### **Final Report - Corrections Required** **Application No. ANEX-24-0004**

**Description : Matrix Design Group on behalf of Colorado Springs Equities LLC is submitting a serial annexation petition for seven parcels and Land Use Plan/Rezoning exhibit for a portion of the subdivision known as Rock Creek Mesa.**

**Document Filename : Rock Creek Mesa Addition No 3\_Petition\_V3\_5-13-24**

## ROCK CREEK MESA ADDITION NO. 3

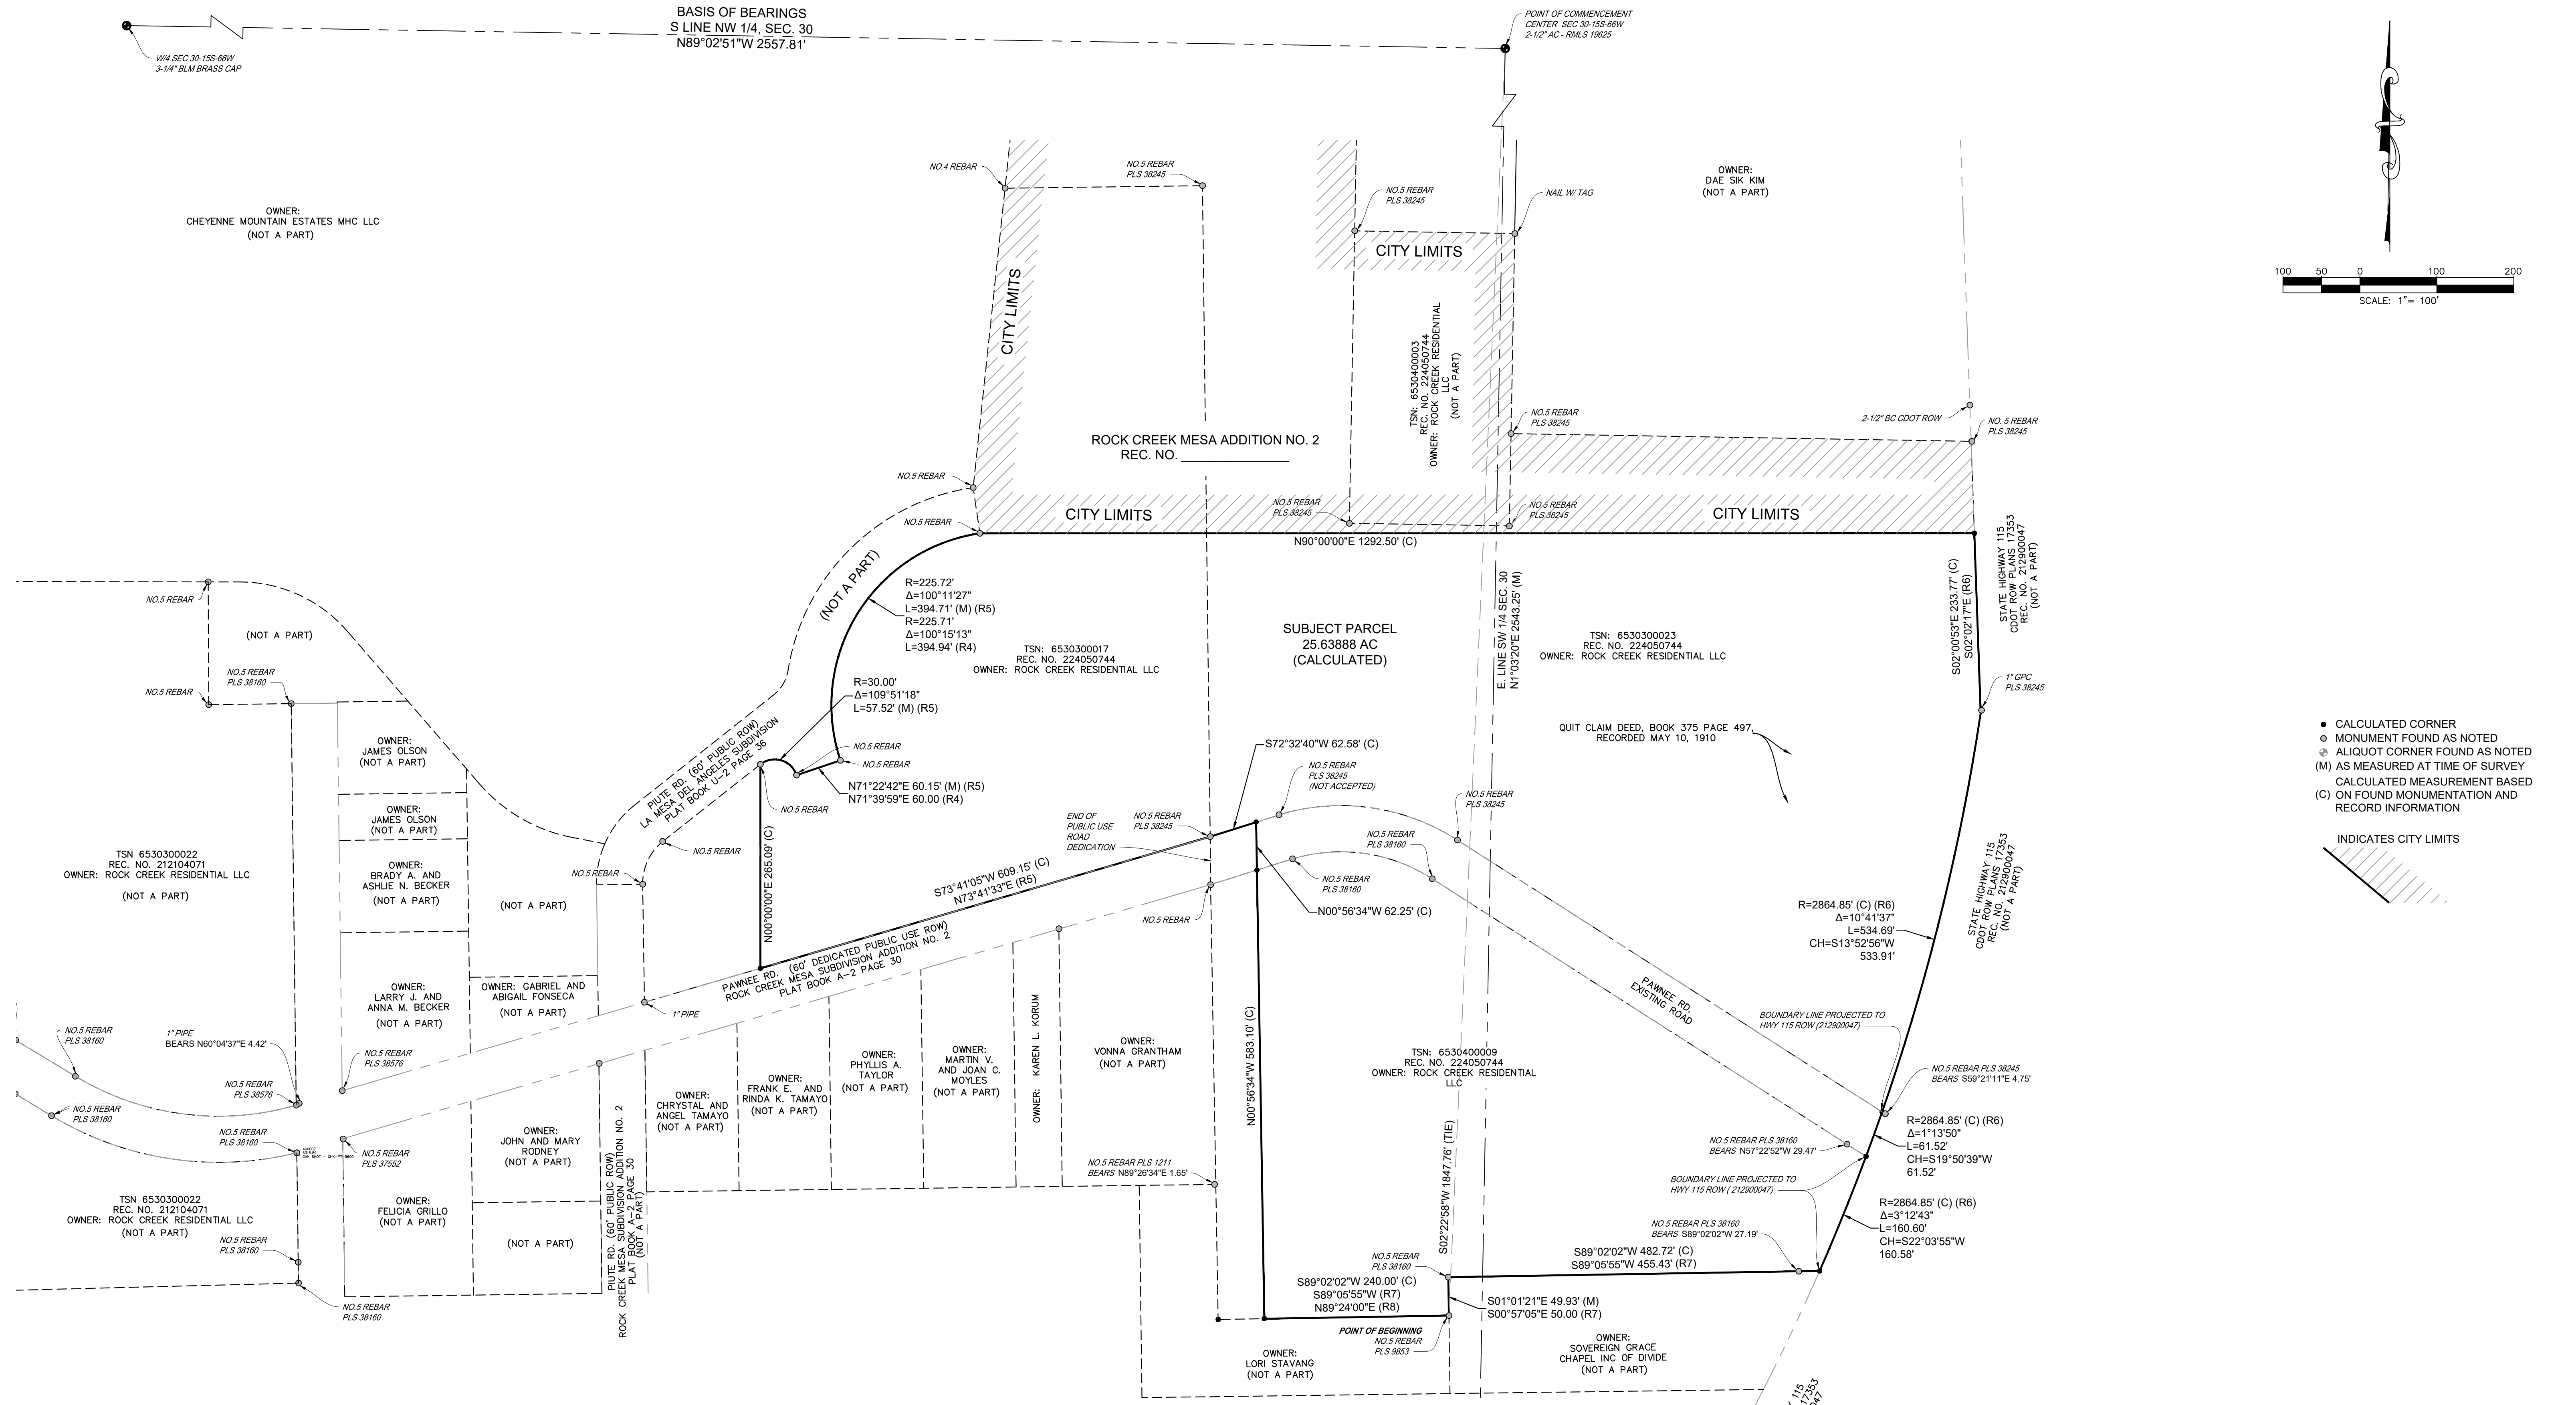
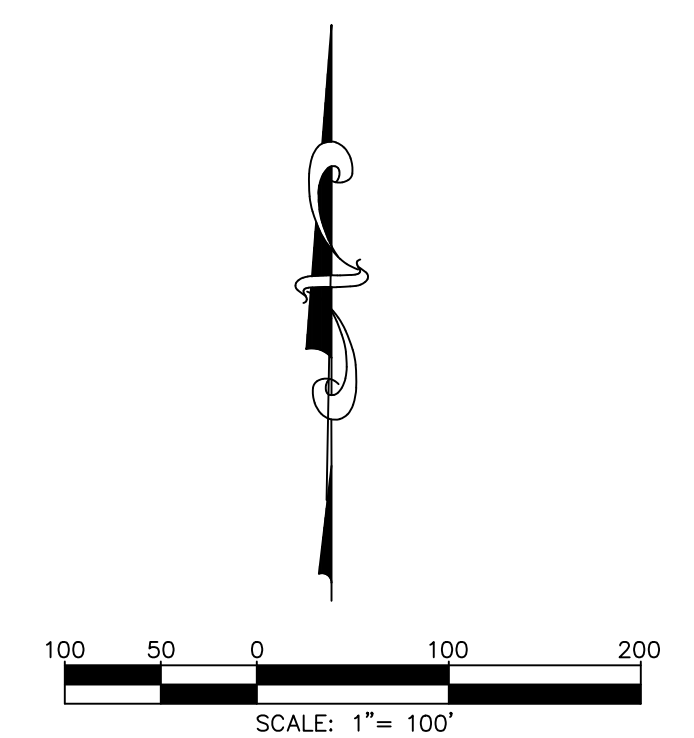
<b>Comment ID</b>	<b>Page Reference</b>	<b>Reviewer : Department</b>	<b>Review Comments</b>
55	1	Gabe Sevigny : Planning	Update legal description per Surveyor comments
